# ENG-CDR23021-R1-CDs-GEC-S2.pdf Markup Summary

**Subject:** SW - Textbox with Arrow  
**Page Index:** 1  
**Date:** 2/21/2024 10:18:04 AM  
**Author:** Glenn Reese - EPC Stormwater  
**Color:** ■  
**Layer:**  
**Space:**  
**Page Label:** [1] 28 Cover

SHEET  
**GEC.1** 11

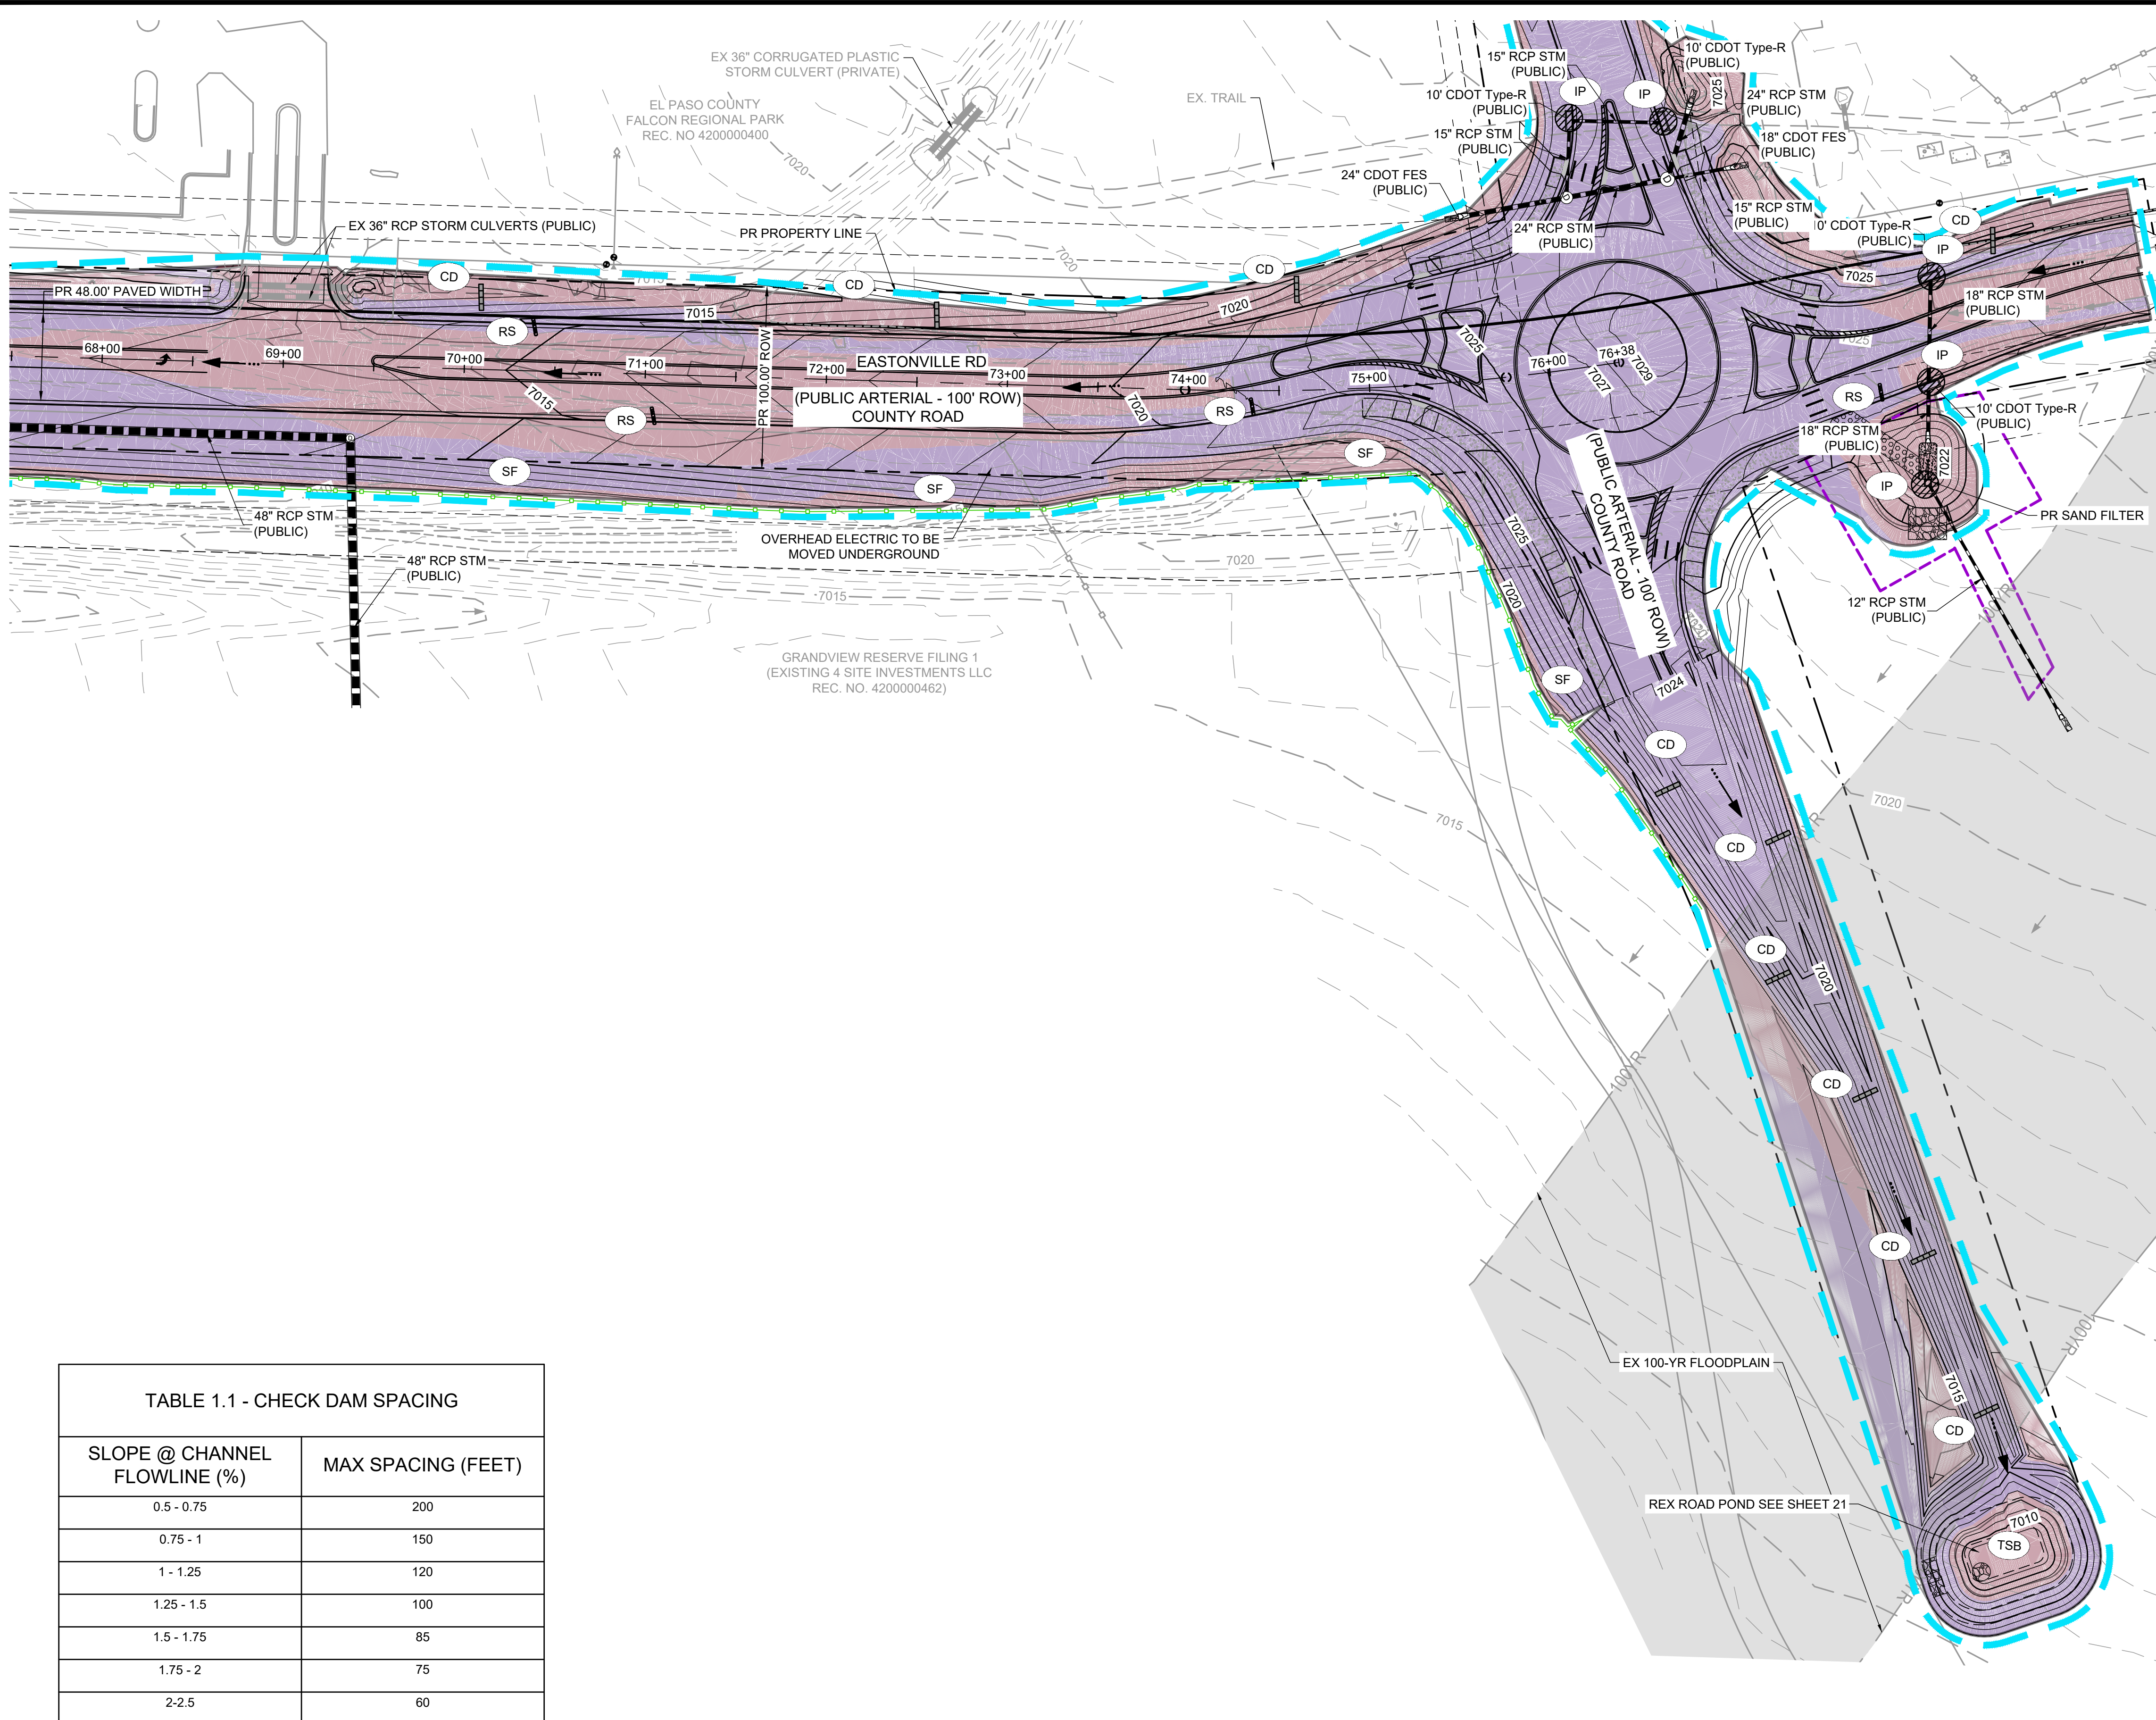
Check dams to be installed a minimum of every 1.5' of vertical fall. Notate spacing and/or include a table for multiple slopes, based on your selected detail.

Since you have already provided a table, add to it which check dam type you anticipate because that will effect the spacing.

GEC Checklist Item "s" - provide more drainage flow arrows. Only a couple are currently shown.

Provide details for all temp BMPs shown on GEC Plans.

Consider need for a VTC here.

SHEET  
**GEC.2** 12

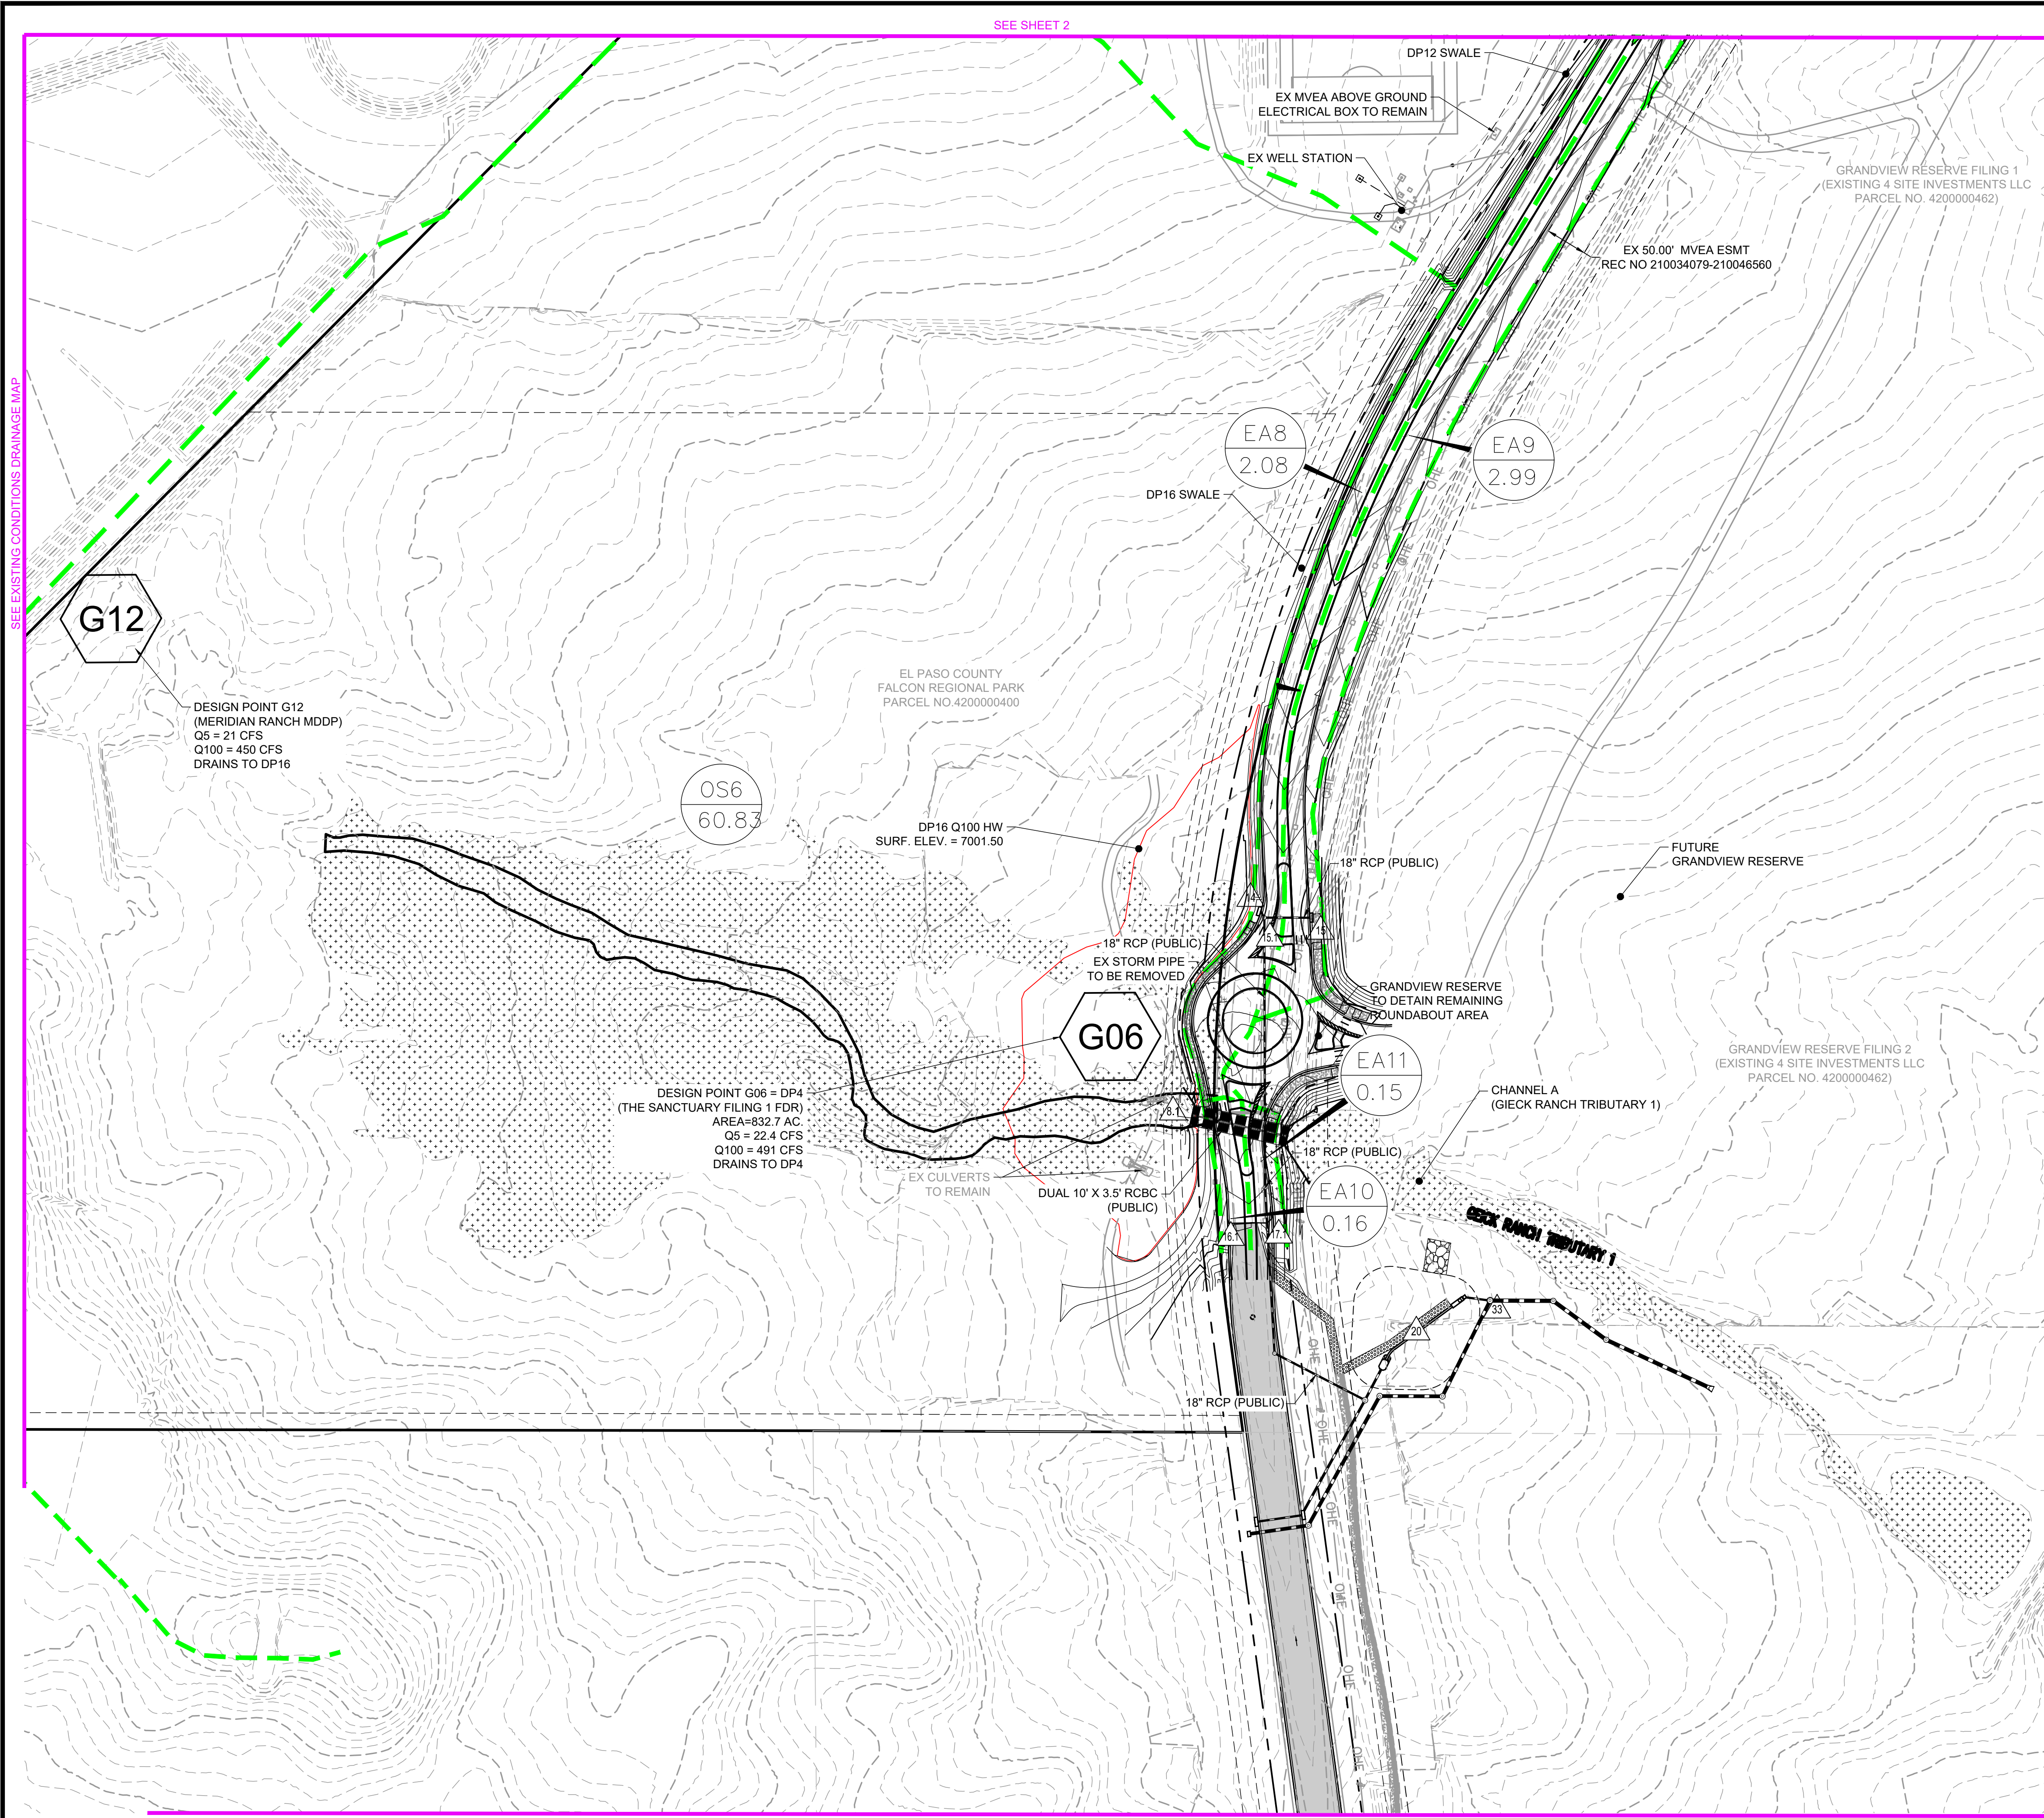
Clarify that this is "Sand Filter C"

TSBs are required for disturbed areas >1ac.

Is this going to be used as a TSB? If so, label accordingly. And:

Provide details of temporary sediment basin including riser pipe diameter and perforation sizing, number of rows of holes, required volume, location of outlet pipe and spillway, and tributary area to the sediment basin. And provide contours for sediment basin.

Show all proposed grading within the LOD.

Consider need for a VTC here.

Approved CLOMR required prior to construction. LOMR required post-construction.
